Sewall Wetland Consulting, Inc.

RE: Technical Review 1 response – 104th Street LLC/Dells Nursery
City of Marysville #PA22041
SWC Job #20-149

This letter is a response to the comments regarding critical areas for the Dell's Nursery rezone in your December 22, 2022 Technical Review letter.

Preliminary Site Plan

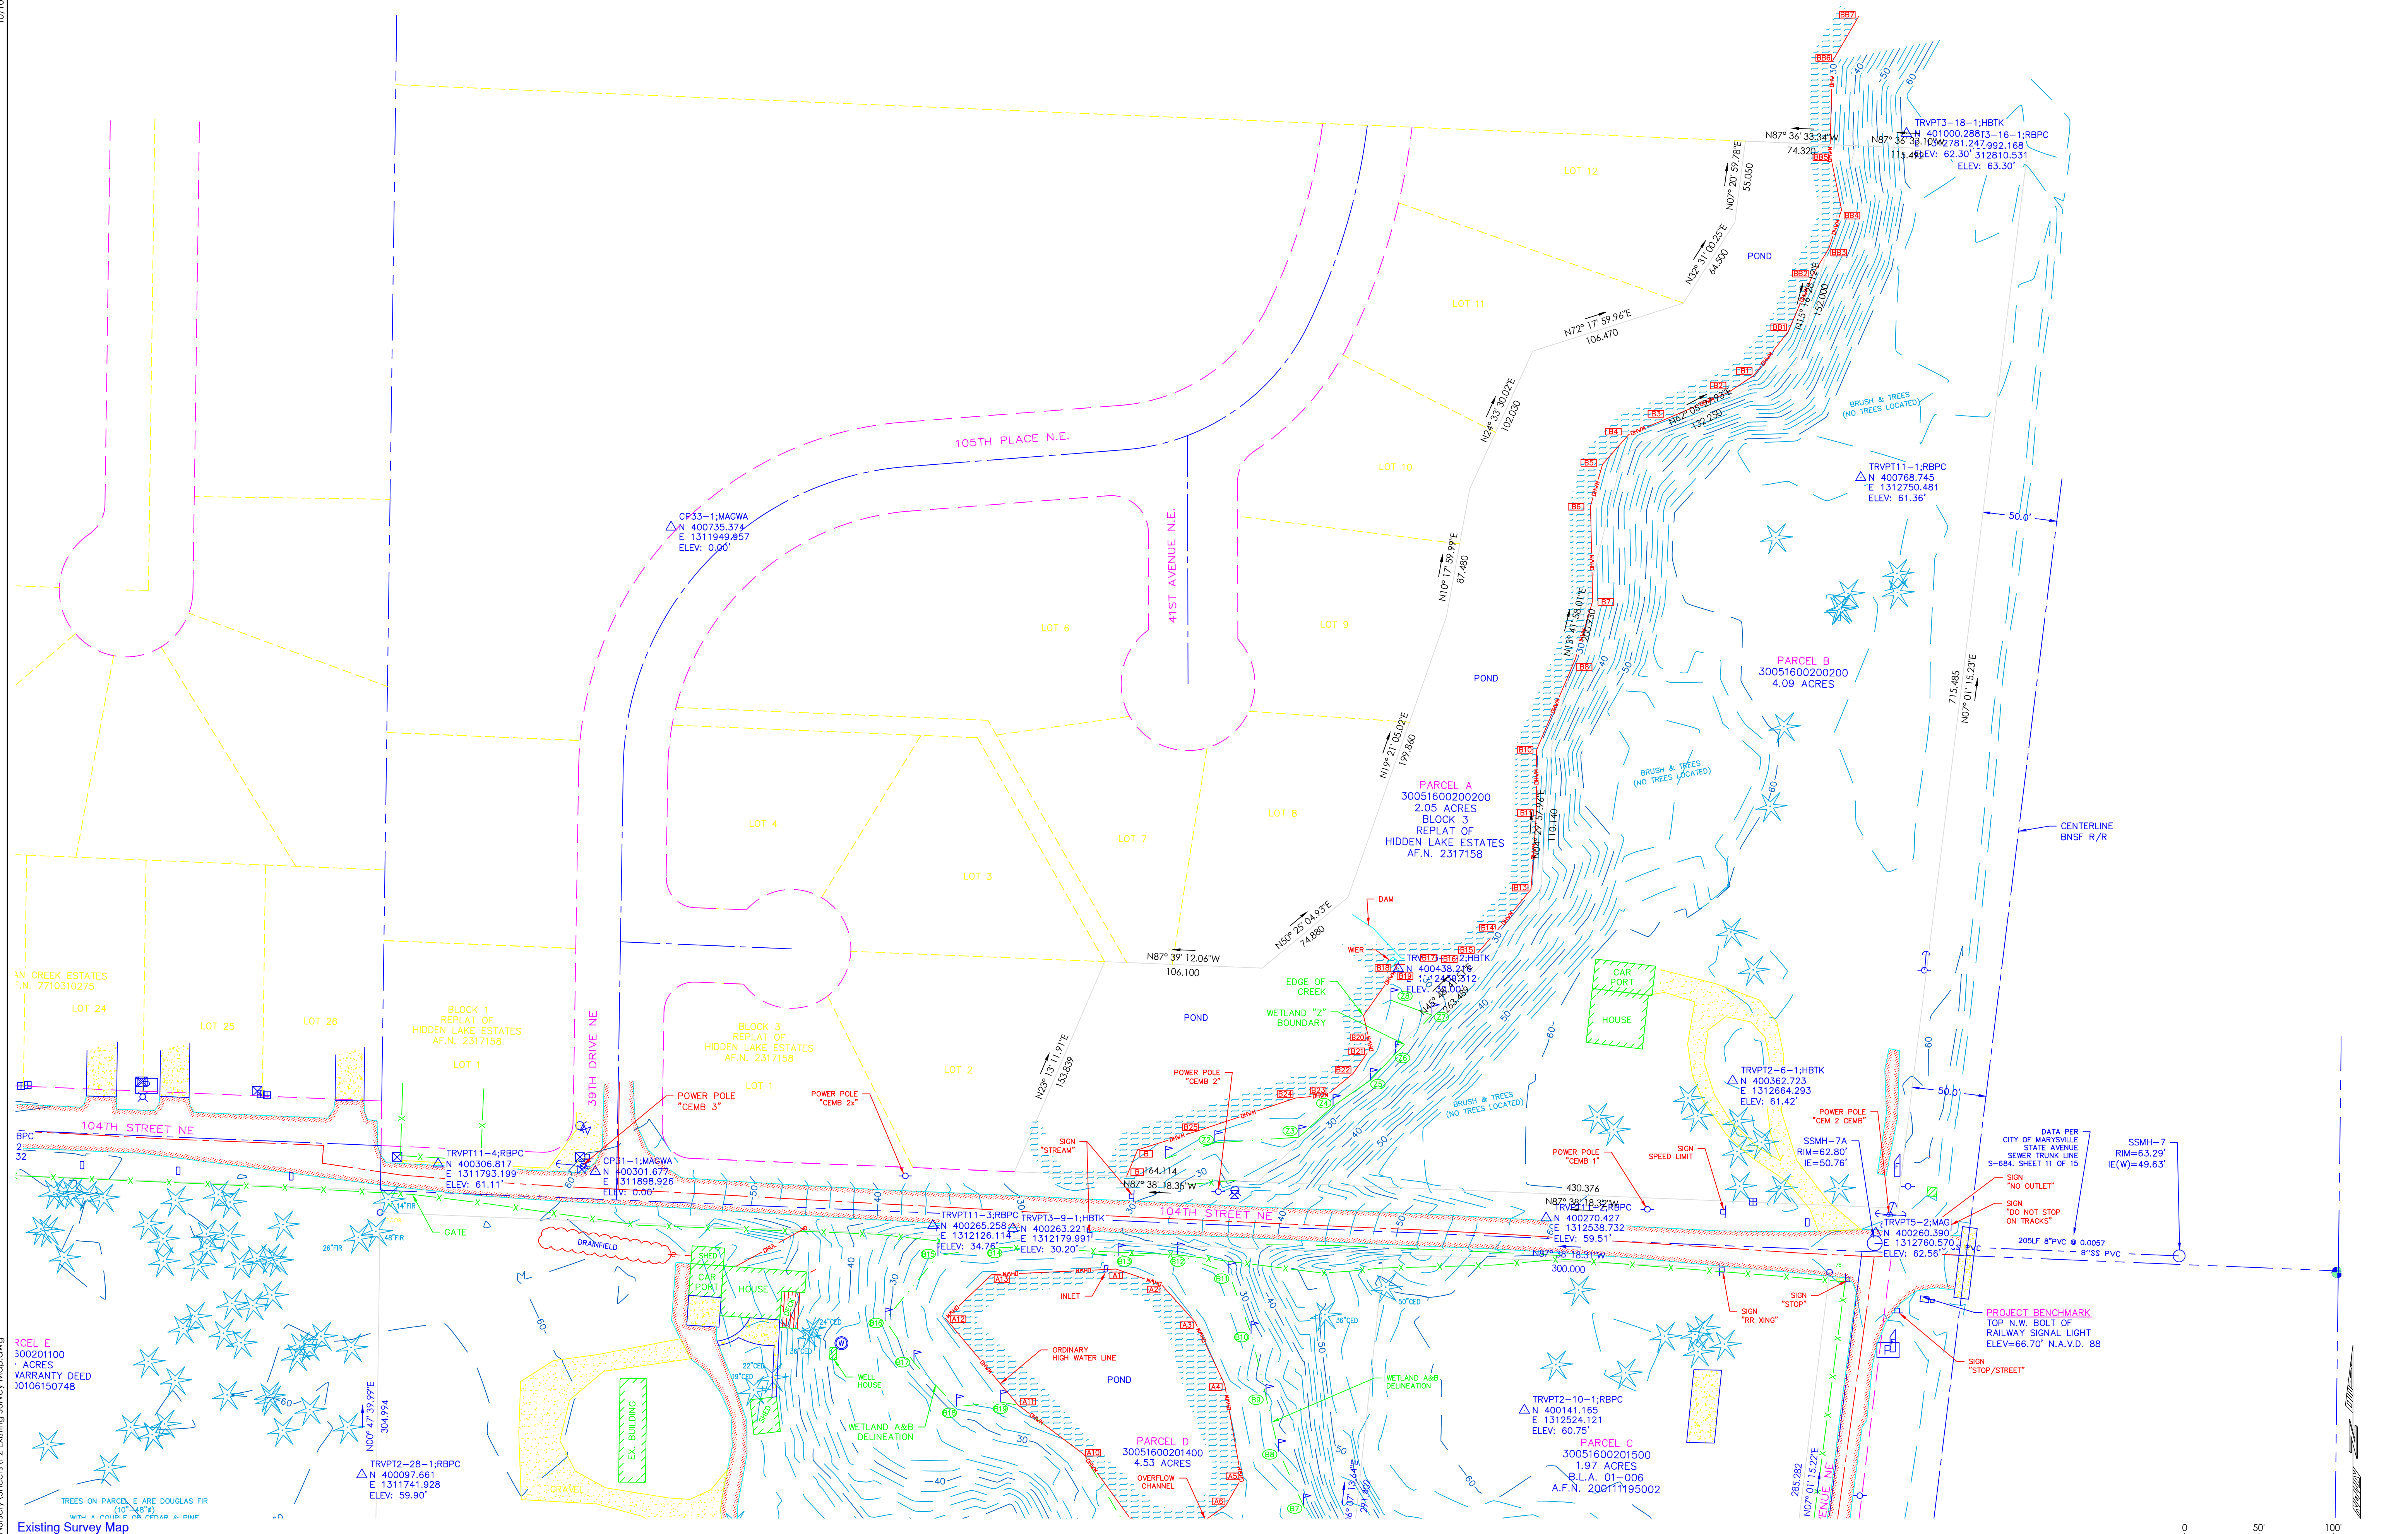
The Site plan and other drawings show the wetland boundary/edge of water based on a 2006 survey. We only trust wetland boundaries for 5 years so did Ed Sewall actually flag this boundary/ Or did he just confirm that a 16 year old delineation looked about right? He did his site visits in 2018 & 2020 but it wasn't clear whether he had the boundary resurveyed.

Response: I flagged the critical areas on the site on September 10, 2018. I then revisited the site on August 13, 2020 and confirmed there were no changes from the 2018 flagging, and that the flags were still present. So the flagged delineation was confirmed in August of 2020..
